Application Ref:	3/2022/0436	 Ribble Valley Borough Council www.ribblevalley.gov.uk
Date Inspected:	23.05.22	
Officer:	KH	
DELEGATED ITEM FILE REPORT:		Decision Call in and Refused.

Development Description:	Prior notification application for the proposed conversion/ redevelopment of two agricultural buildings into two dwellings.
Site Address/Location:	Land adjacent to Miles Hill, Moor Lane, Billington BB7 9JH

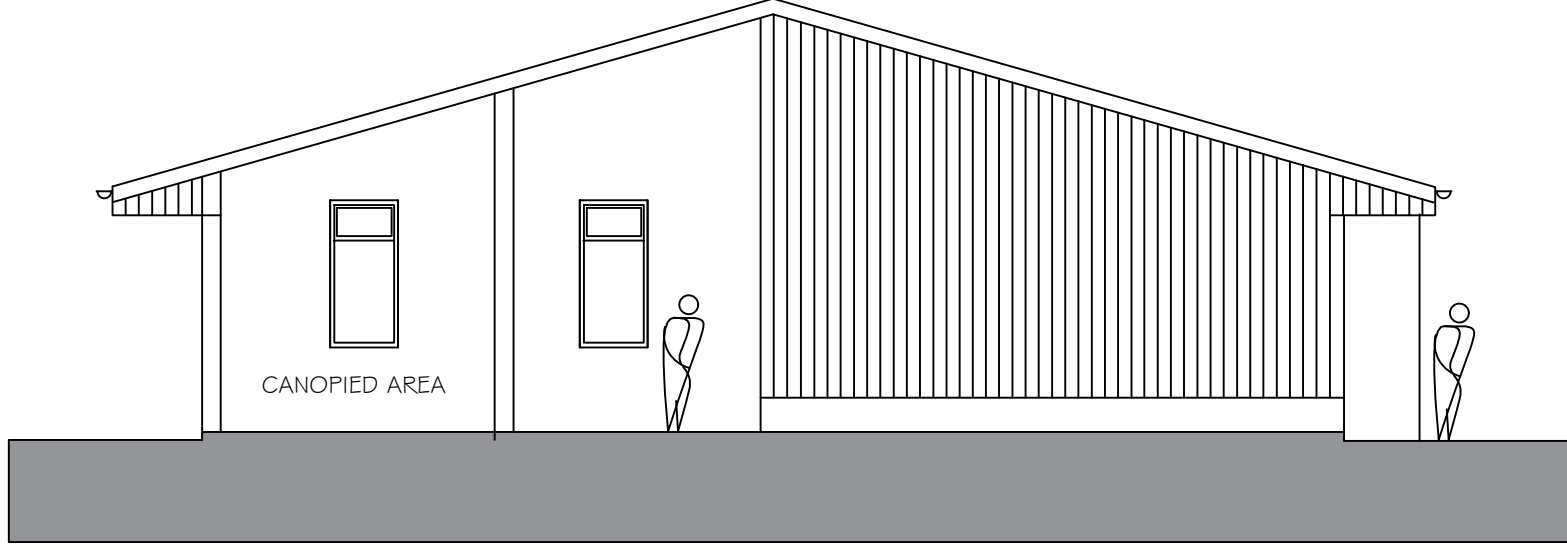
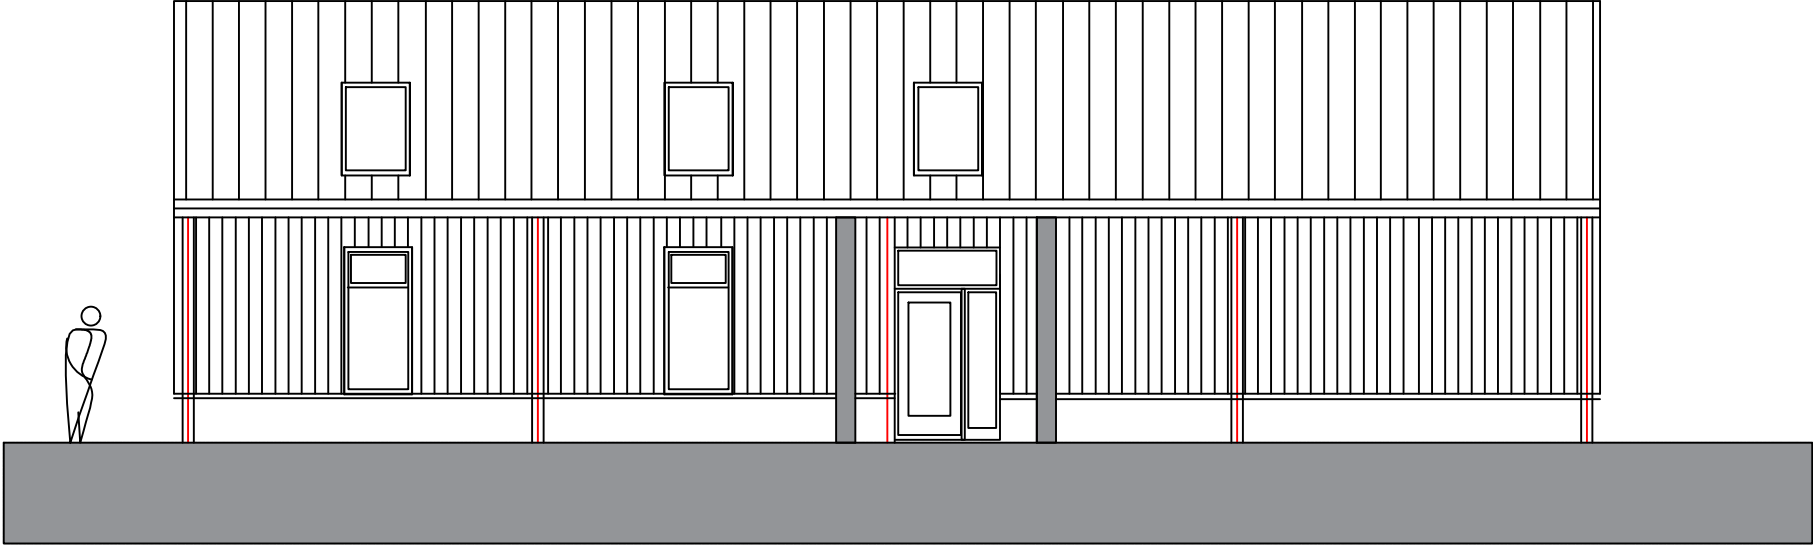
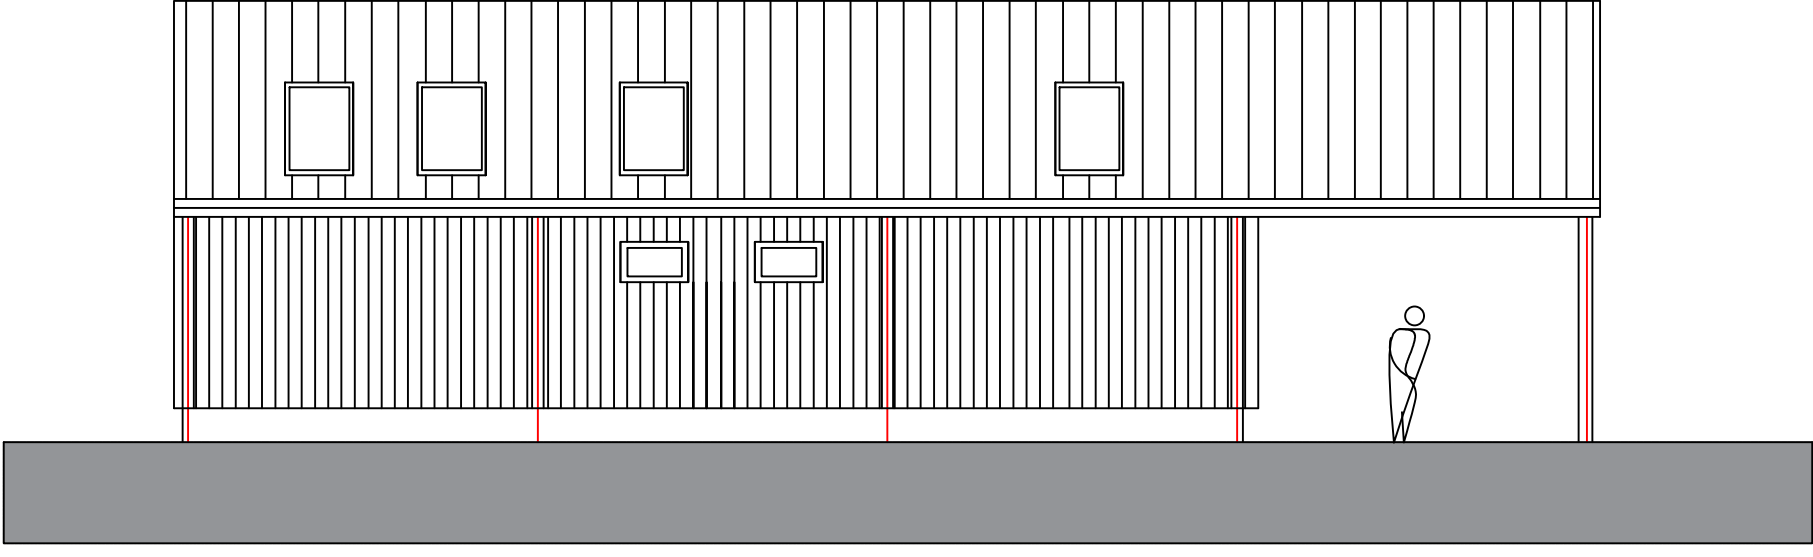
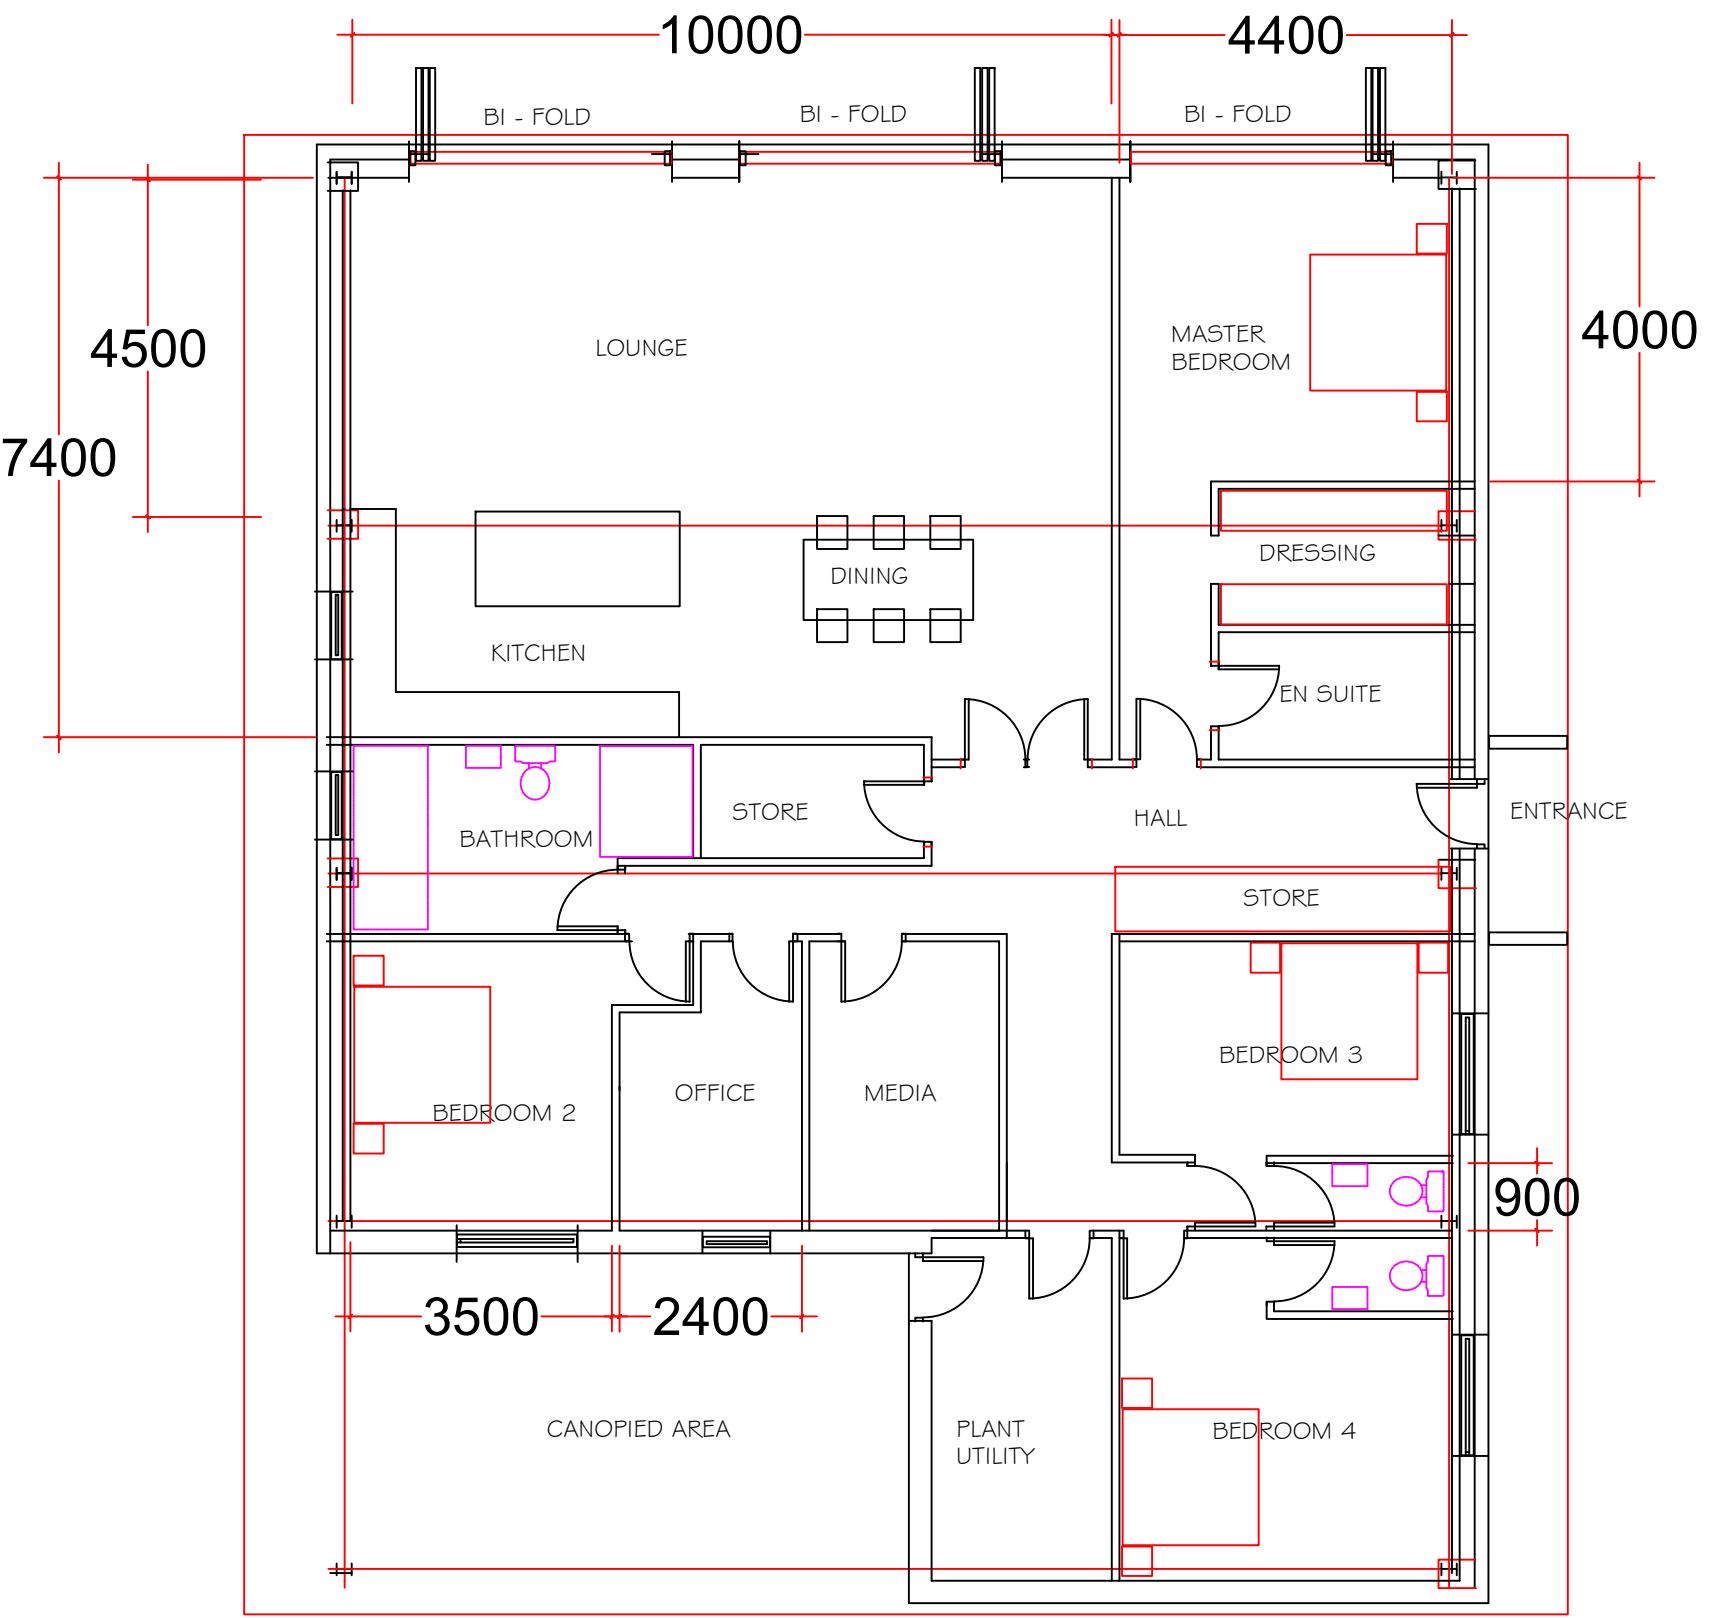
The proposed dwellings seek to retain the existing structure with additional windows to the north east and south west elevation and rooflight to these roof slope for plot 1 and additional windows and doors to all elevations and roof light to the south west roof slope for plot 2.

The buildings on site are relatively modern steel framed buildings which have a functional agricultural purpose. The scheme has the appearance of 'retro-fitting' a residential use into buildings not designed for such a use with additional glazing including bi-fold doors and rooflights in a prominent hillside location. Whilst a modern design is not necessarily unacceptable for agricultural buildings in this case the design would create an incongruous feature within this rural location.

The lack of private amenity space and close proximity of the buildings to each other, which is a result of the nature of the existing site and built form, would result in an unacceptable, cramped form of development in this rural setting to the detriment of the amenity of the area and the amenity of the future residents.

This is not acceptable in terms of design and materials in this location.
